**Shoalhaven Starches - Gas Pipeline (MP10_0144-Mod-1)
Request for Additional Information**

I refer to the modification request for Shoalhaven Starches – Gas Pipeline (MP10_0144-Mod-1). The Department of Planning, Industry and Environment (Department) has reviewed the modification request. After careful consideration, the Department is requesting that you provide additional information that effectively addresses the issues in **Attachment 1**.

ATTACHMENT 1
Department's Comments

GAS FACILITY.MOD 1. SITE PLAN.

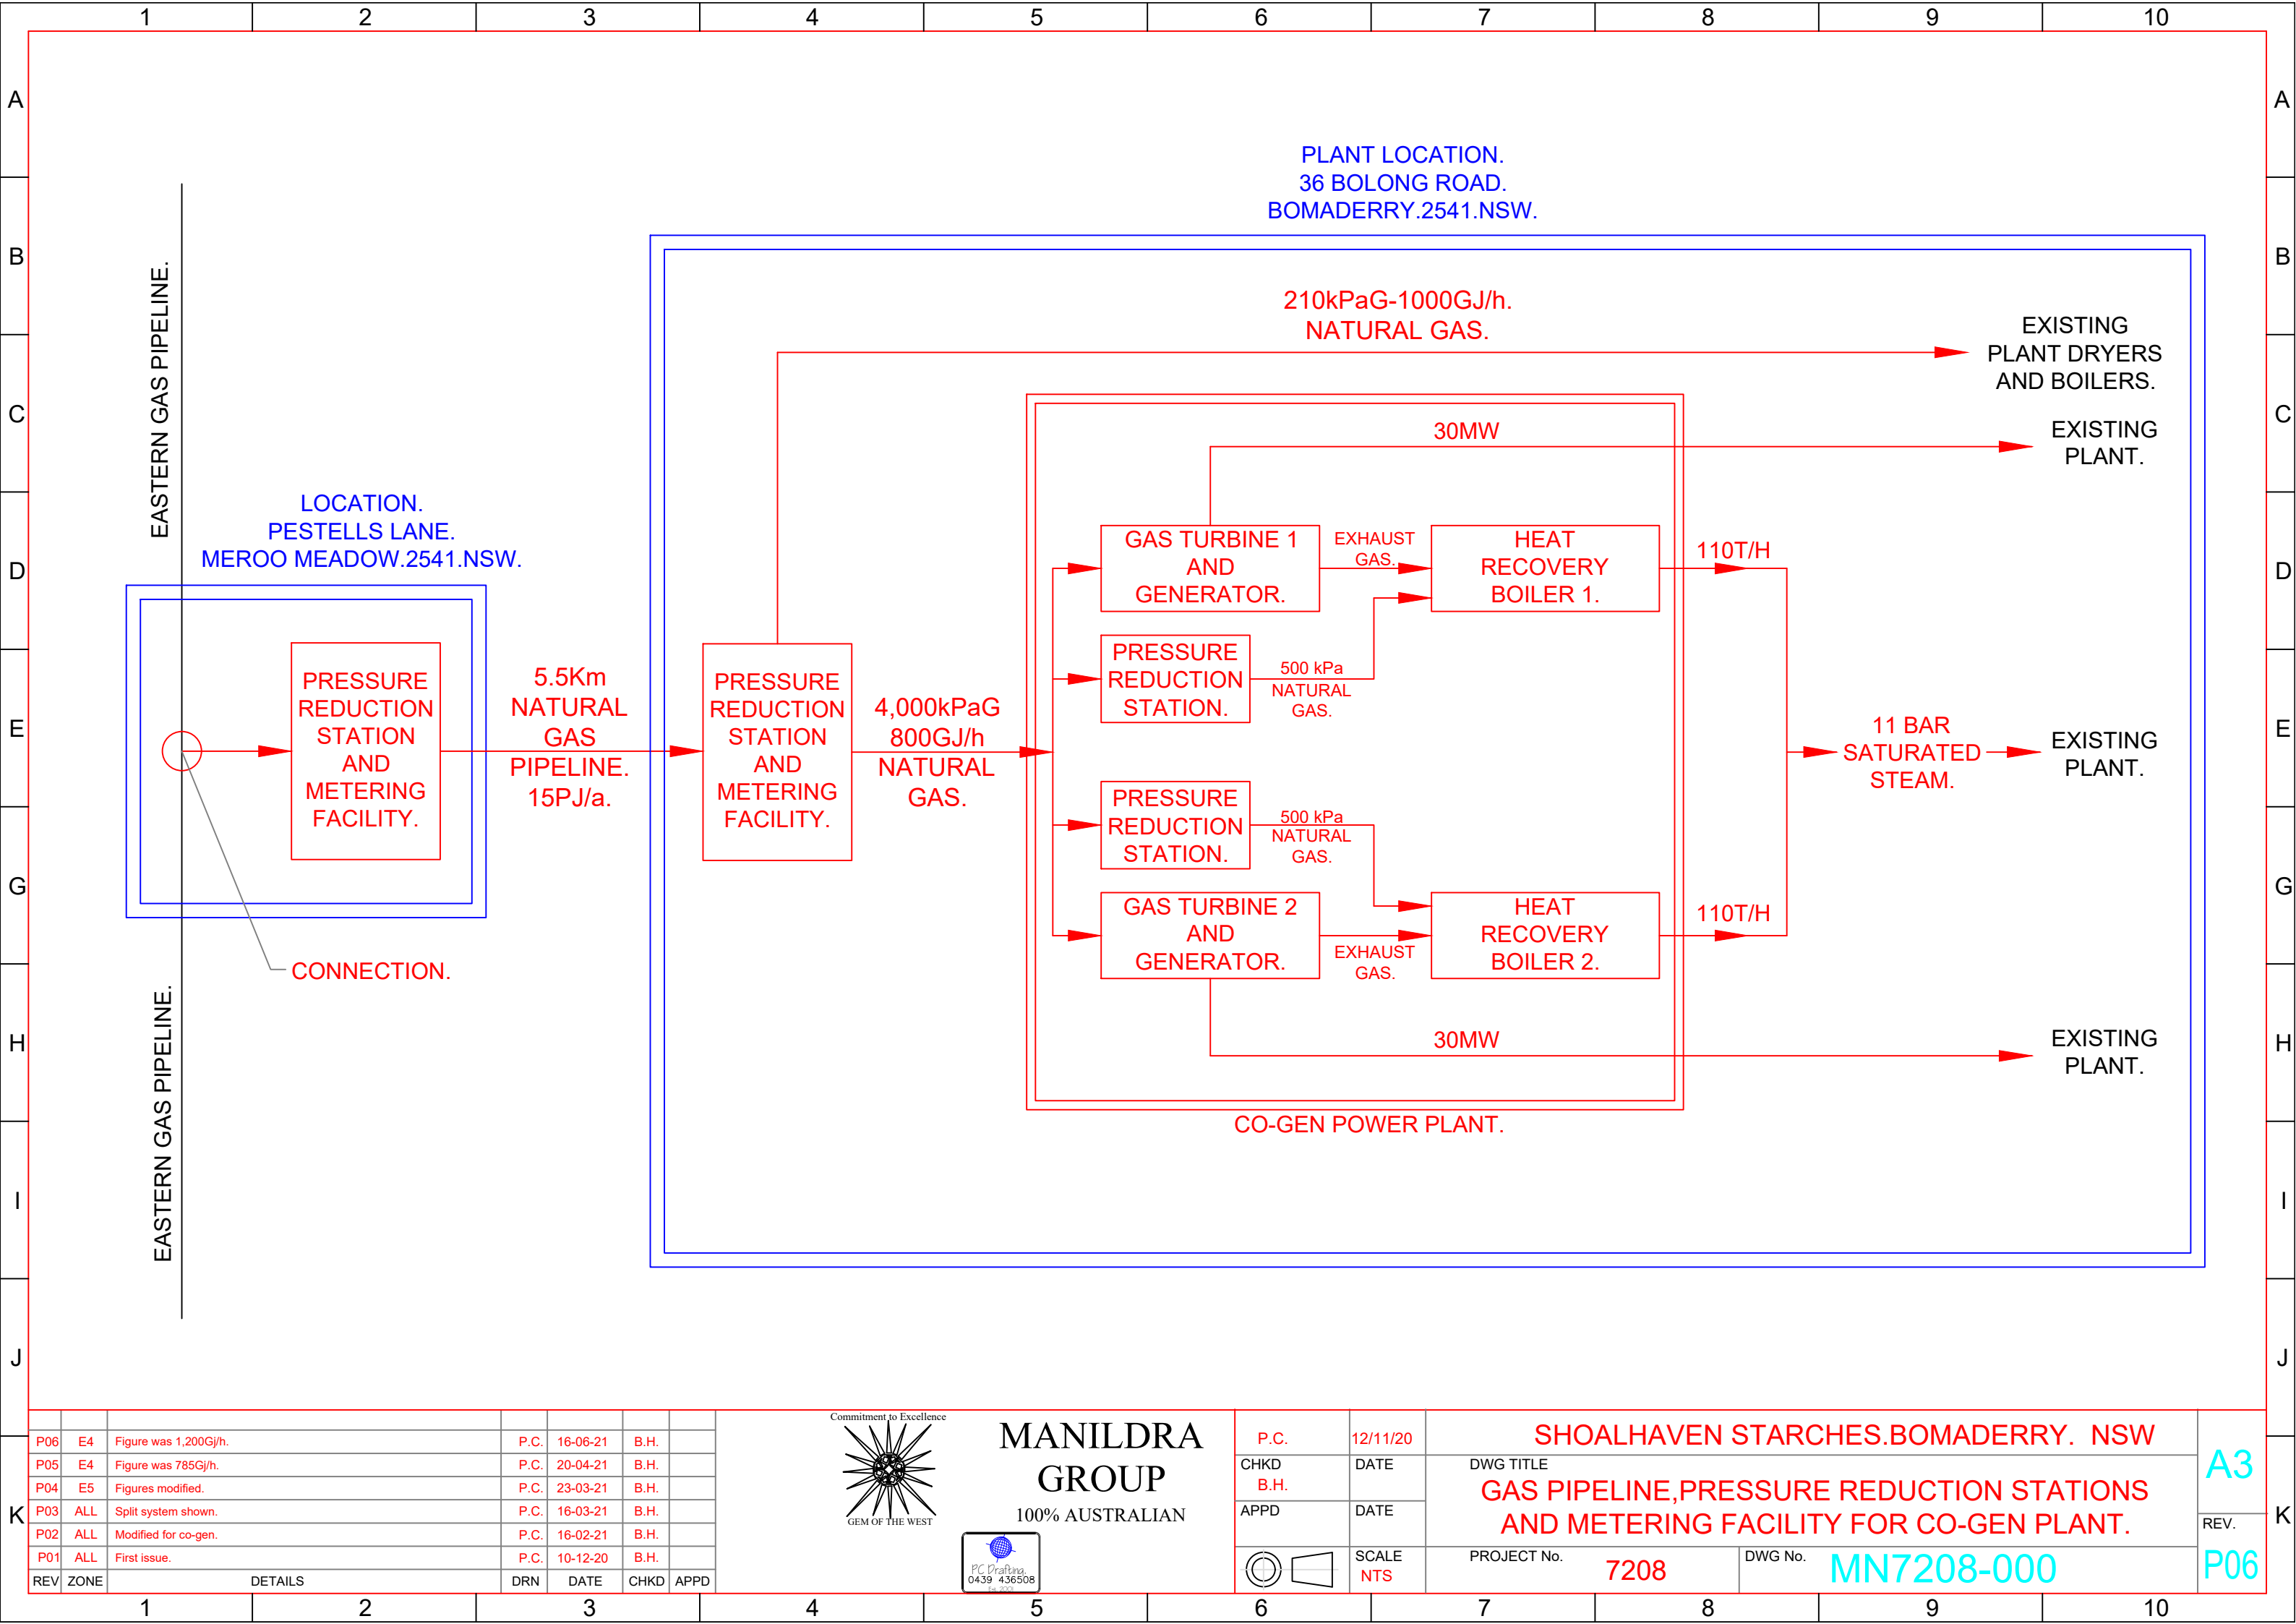
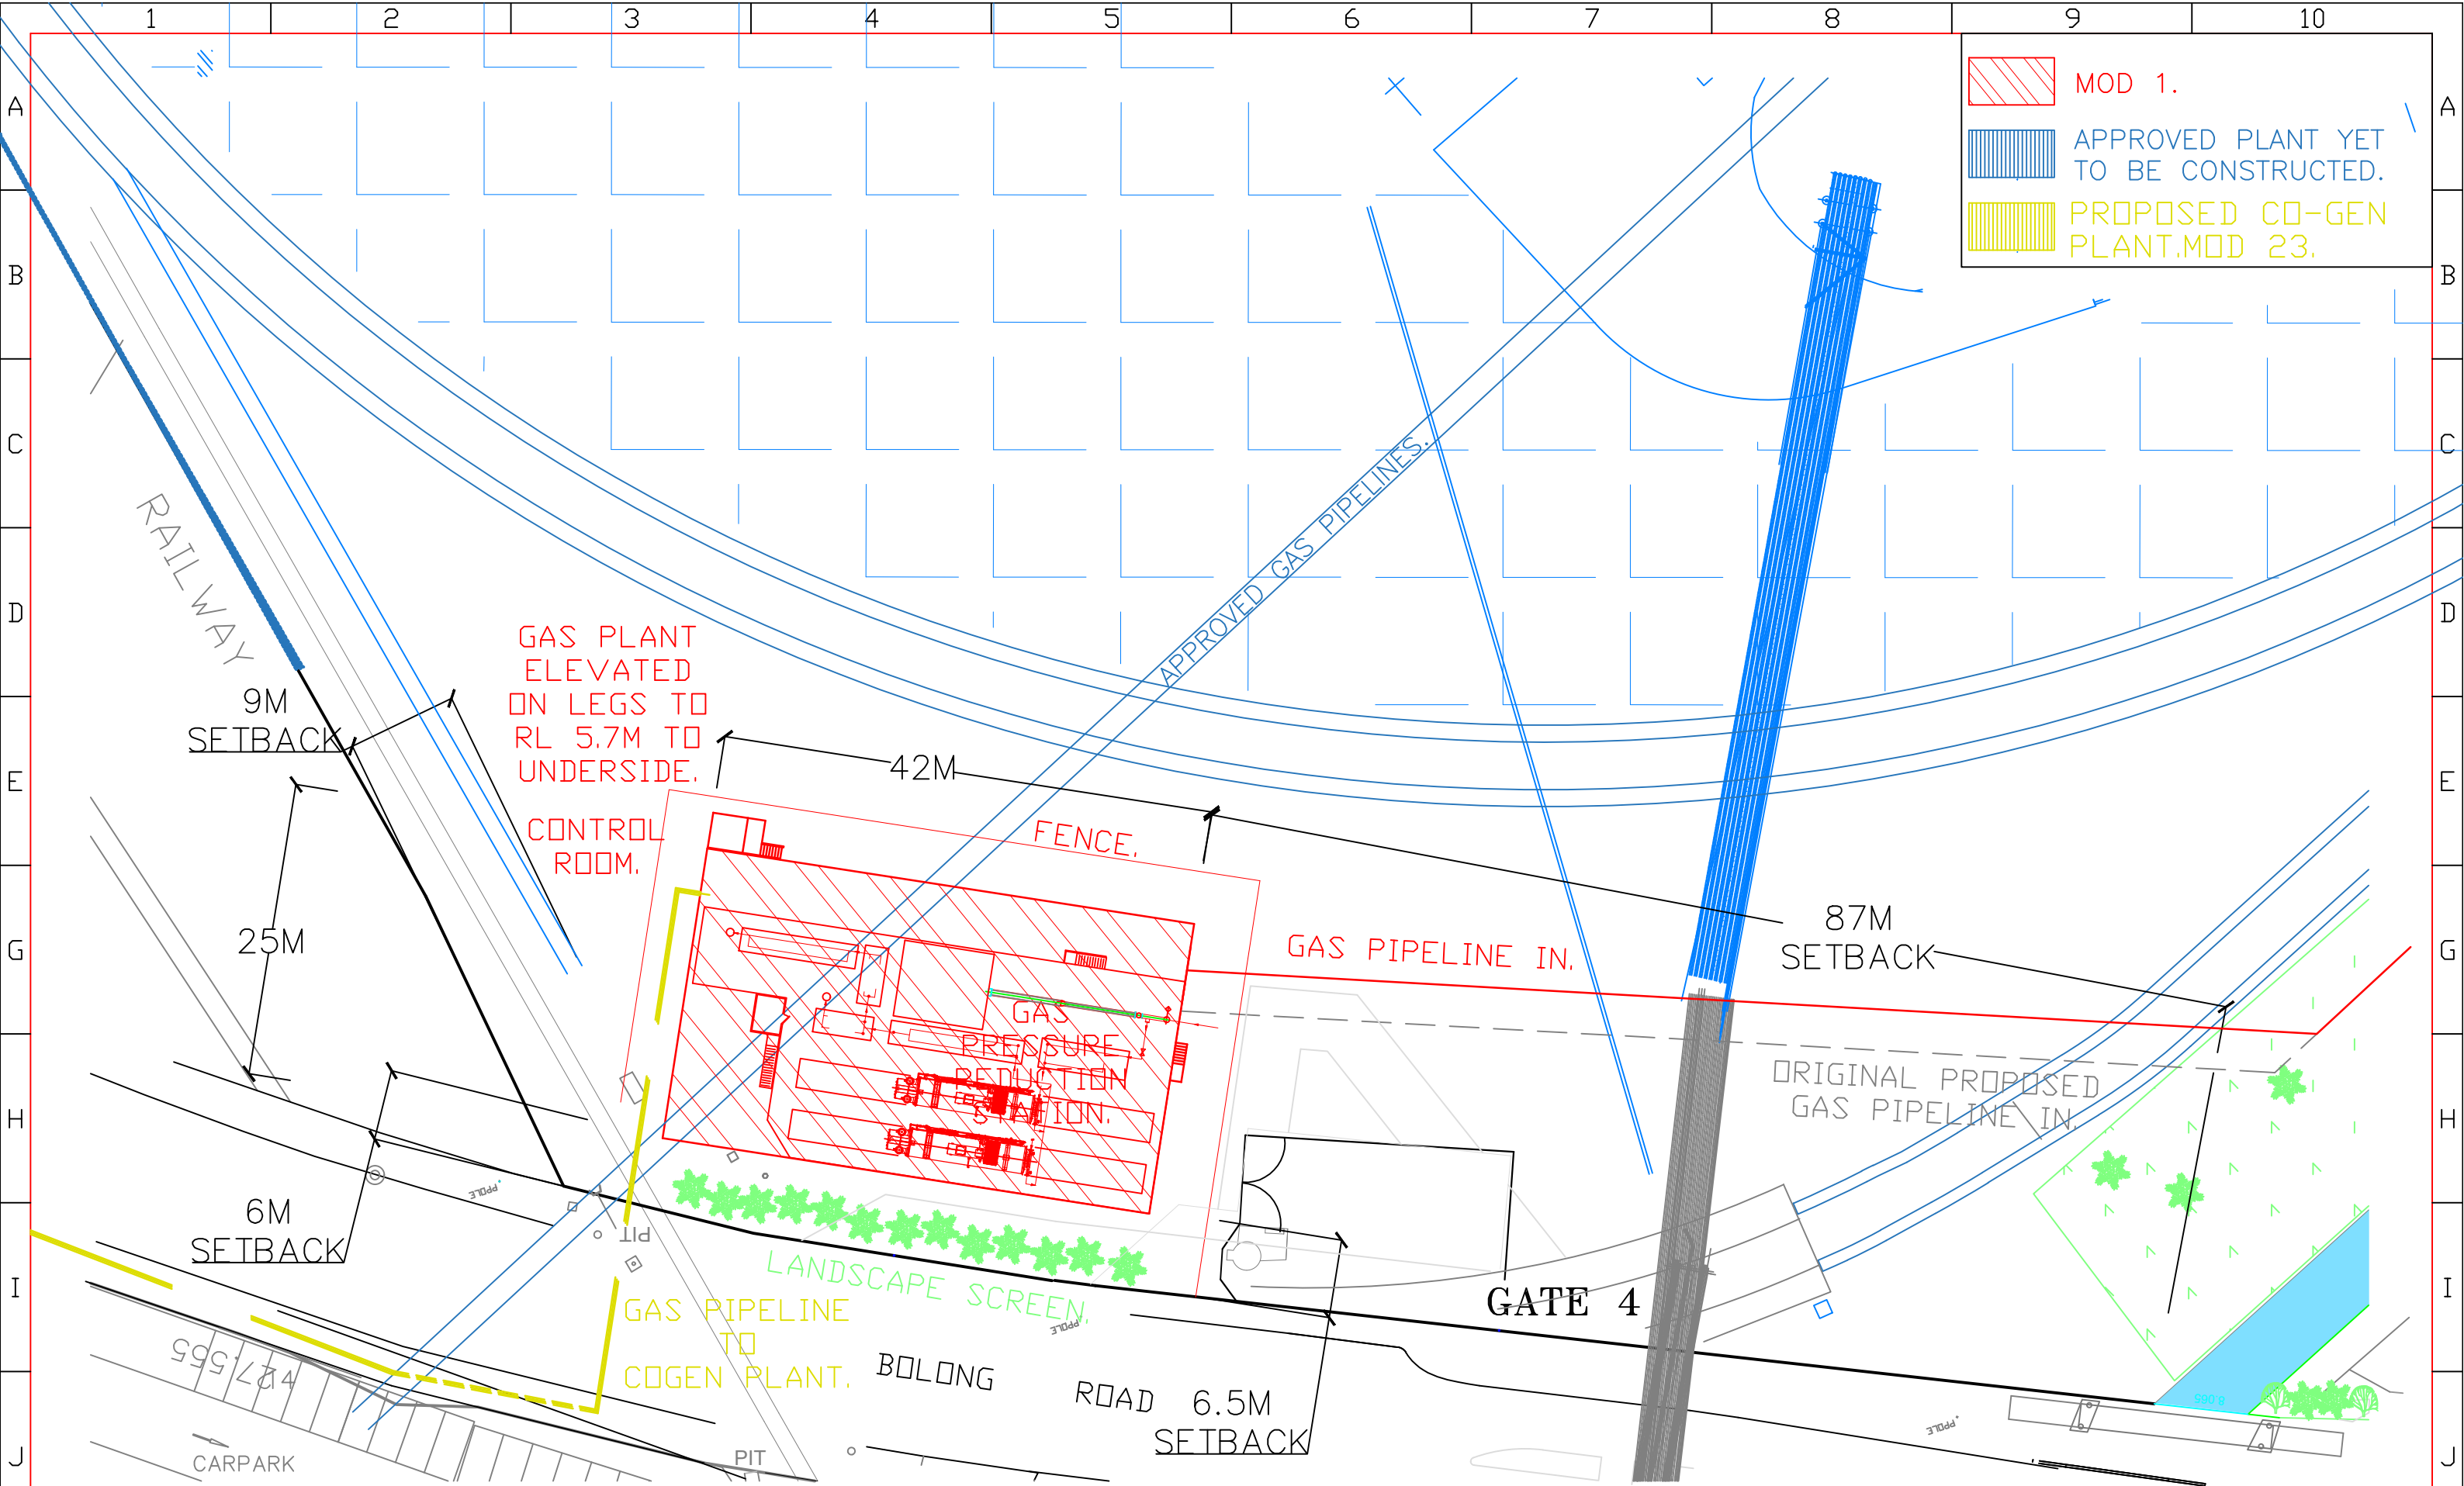
4. The relocation of the Gas Pressure Reduction Facility (GPRF) closer to Bolong Road decreases the separation distances to surrounding areas. Noting that the GPRF is now closer to the distillation plant, the PHA must demonstrate that the consequence of events associated with the GPRF meet the risk criteria in Hazardous Industry Planning Advisory Paper No.4 and that propagation risks are met.
